Application number: 2026/62/91628/W

Applicant Jones Homes (Yorkshire) Ltd

Objection to planning Application

Site Layout Plan

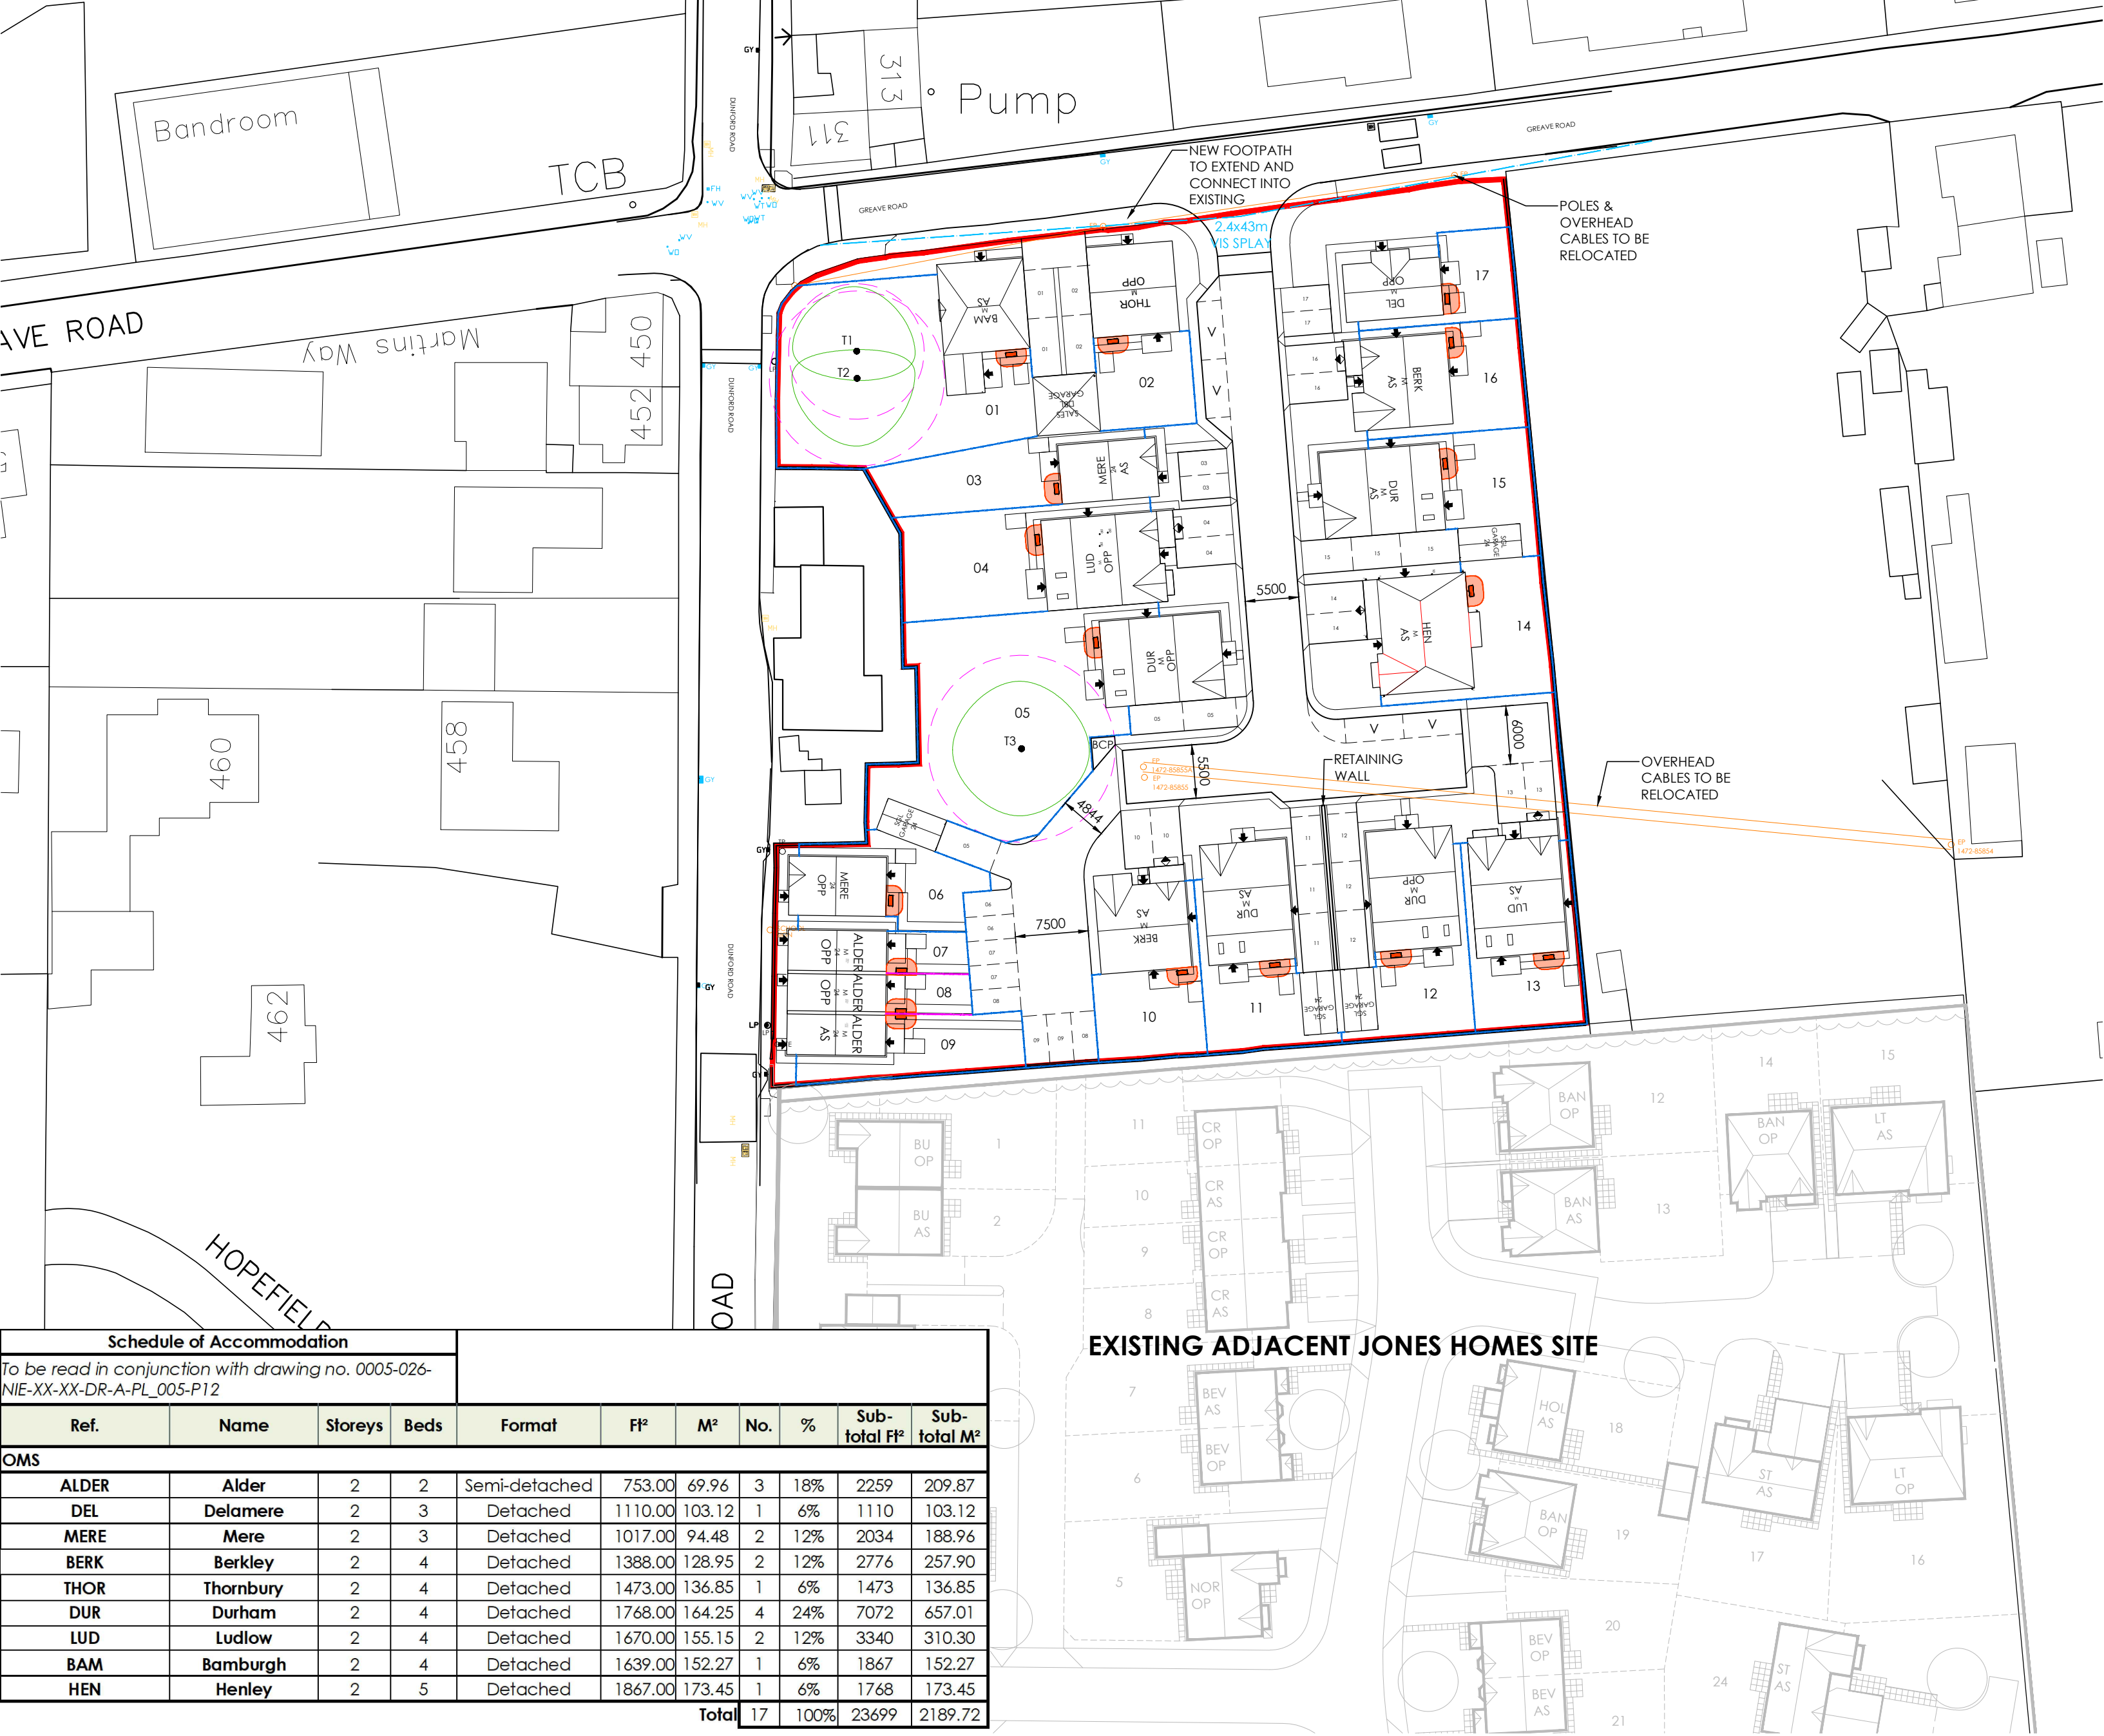
1. The proposed position of property 04 (LUO) rear elevation is not the full 21 meters away from the front elevation of 323 Dunford Road (my house). The Kirklees Housebuilders Design Guide SPD, a material planning consideration when assessing plans, clearly states;

2. The proposed position of property 06 (MERE) along side 327 Dunford Road is too close and will create a negative impact on light and overlooks the entire property and outside space.

The South gable of the commenced dwelling (327 Dunford Road) is only 2.9m, according to the planning approved drawings, to the boundary. It's also important to note this elevation (327 Dunford Road) has no fewer than 4 openings that all serve habitable rooms. There are no dimensions on the Jones homes plans but plot 6 looks circa 1.2m from the boundary. The Plot 6 (MERE) proposed north elevation (directly facing 327 Dunford Road) shows two windows (one at a lower level and one at 1st floor level), directly overlooking the whole of 327 Dunford Road. The

When looking at the planning proposal the distance looks incredibly close – lack of dimensions on the plan make it very difficult to be exact but it seems to be less than 3 meters wall to wall. The layout as submitted, complete with a side path serving plot 6 (MERE), serves to create overlooking, privacy issues and overshadowing of 327 Dunford Road. Plot 6 should be at the very least 12 meters and possibly 21 meters away.

3. Plot 5 (DUR) garage follows the same proximity issues as plot 06 (MERE). The plot 5 (DUR) garage location is incredibly close to 327 Dunford Road’s West elevation which is fully glazed. Again, without dimensions it is difficult to be precise, but the gable of the garage is less than 3 meters from the ground floor windows and will definitely have a negative impact on light, outlook and could overlook depending on the design and use of windows in the garage (no specification provided).
